Please replace submitted Street Elevation Rev A with the above attached (Rev C).

Subject: BR/275/21/NMA

PROPOSED STREETSCENE ELEVATION

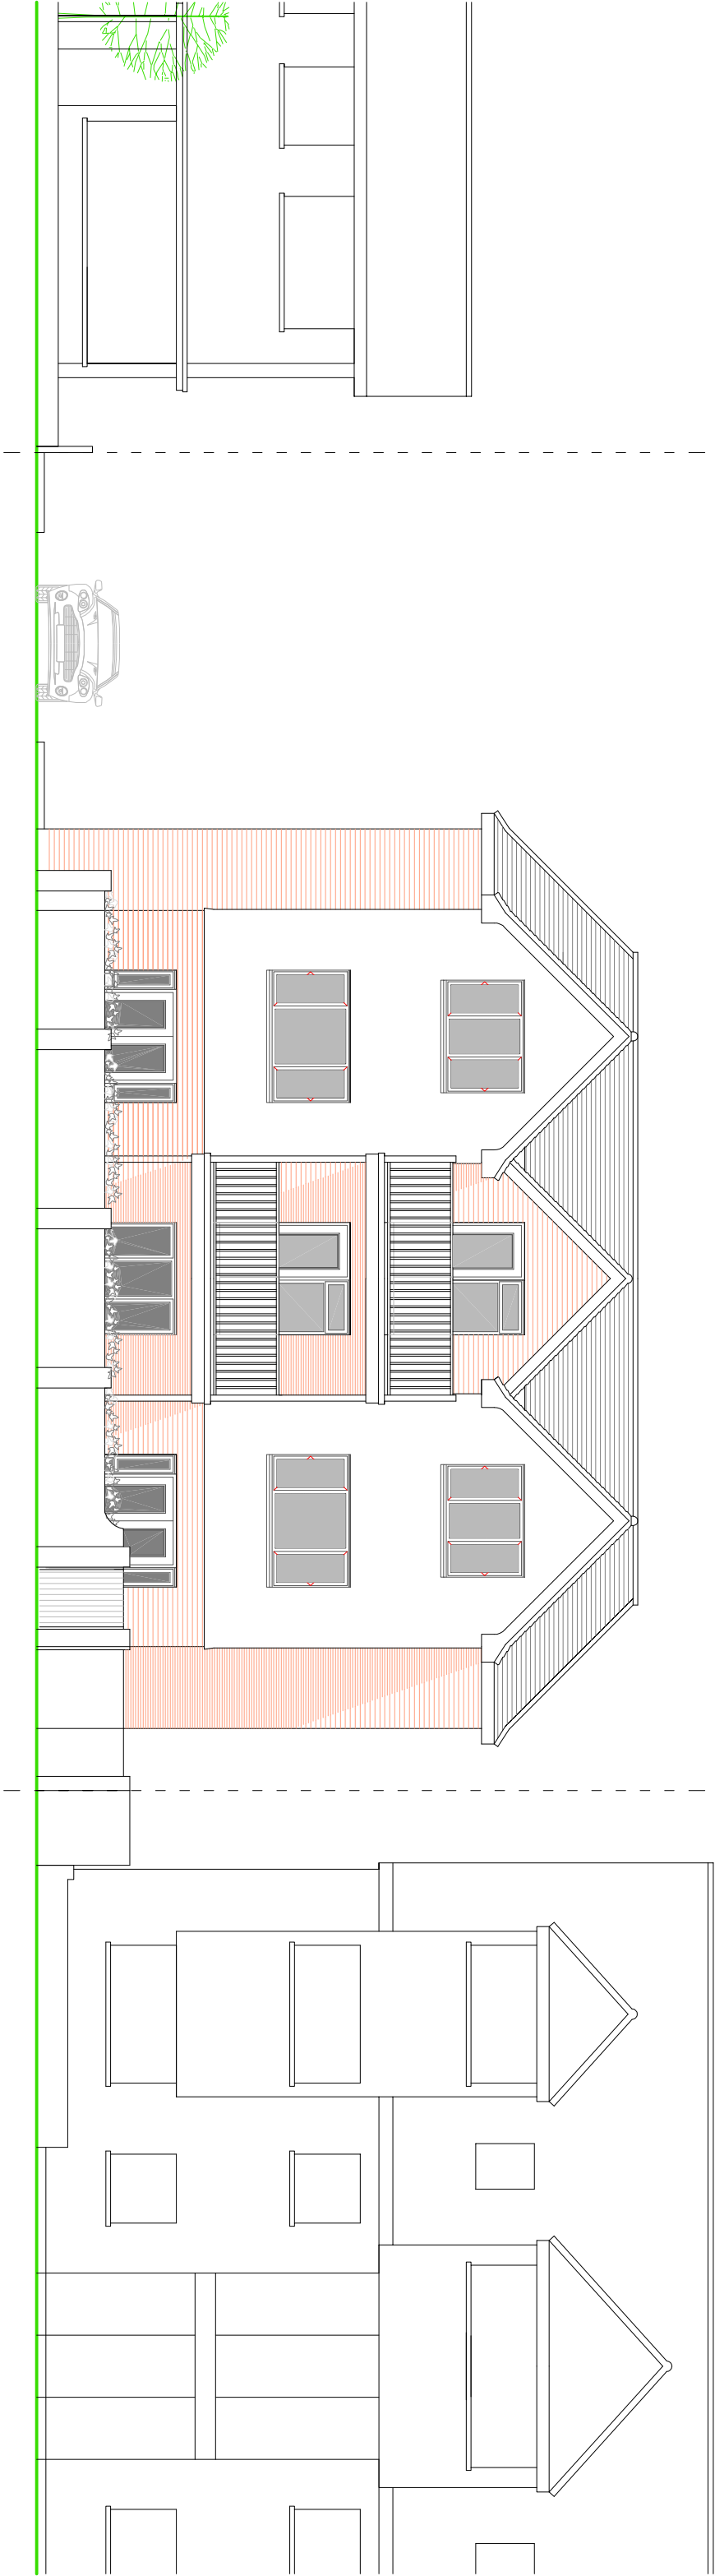
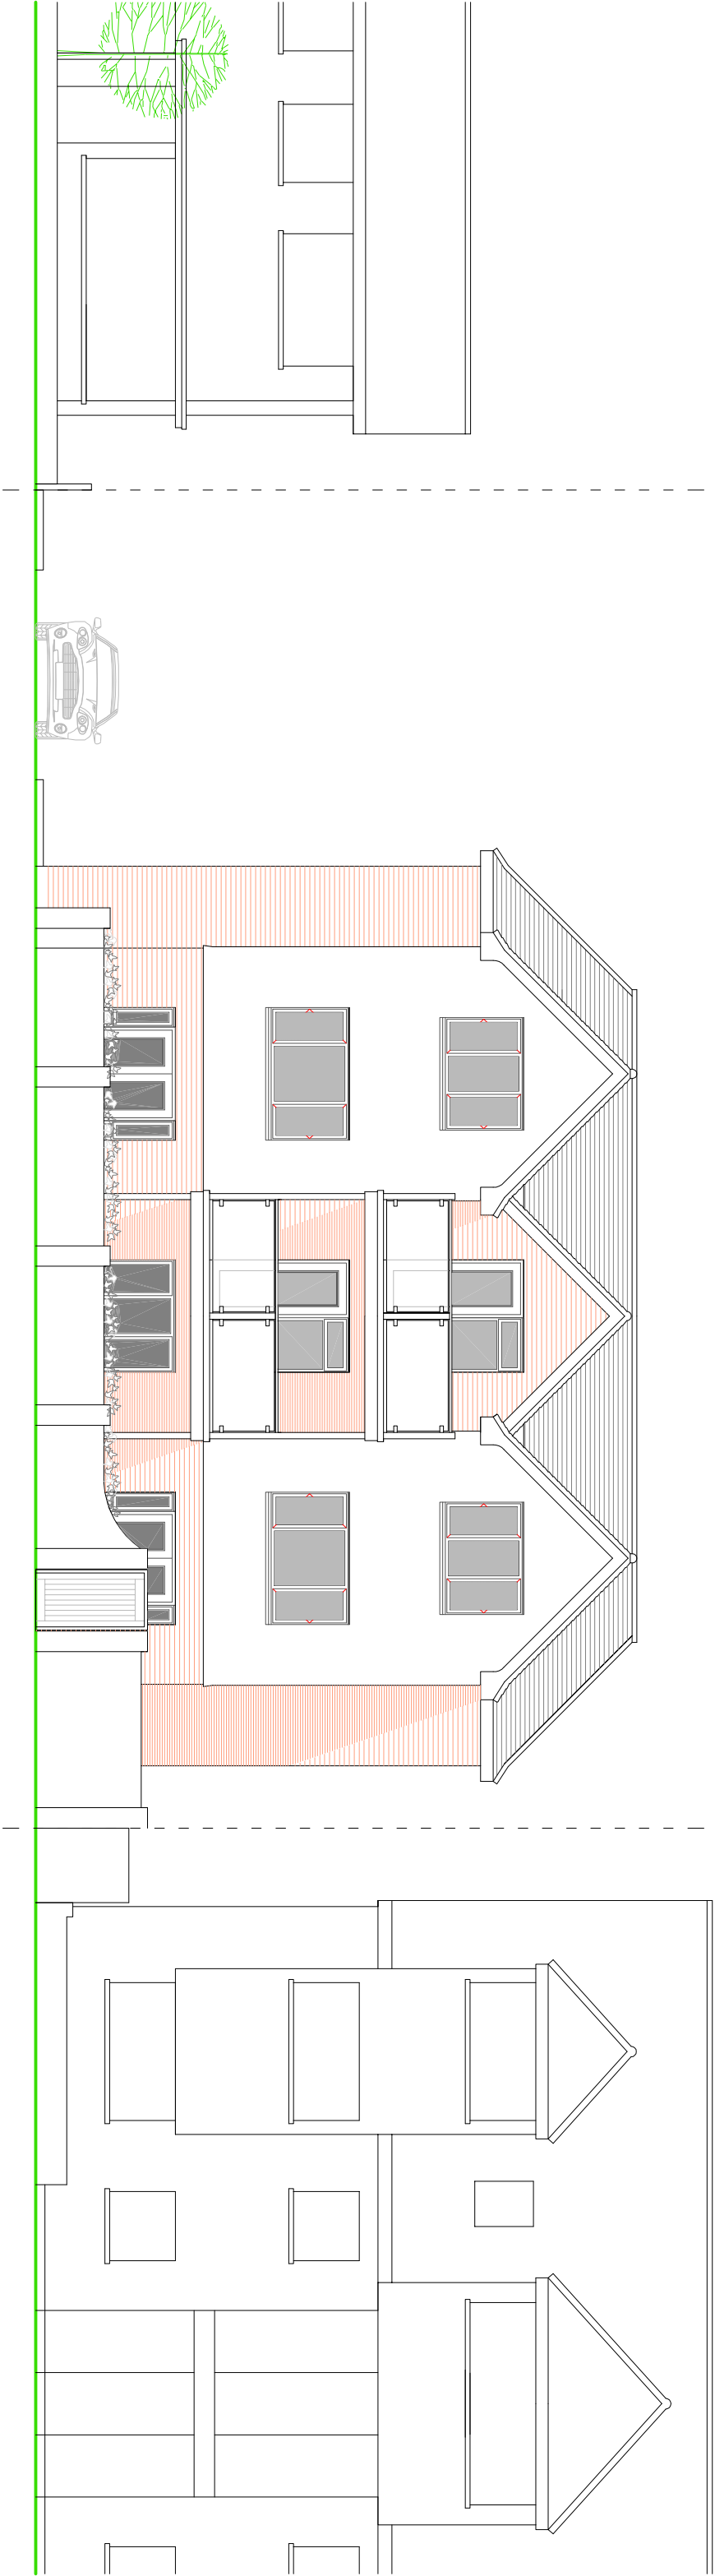
I deal with the above application and I think there is some mistake in the drawings of front elevation (south-east). There is a different railing on the balconies within a 'street scene' and south-east elevation which, I believe, are the same.

I attach the correct 'Street Elevation' for you – sorry missed that.
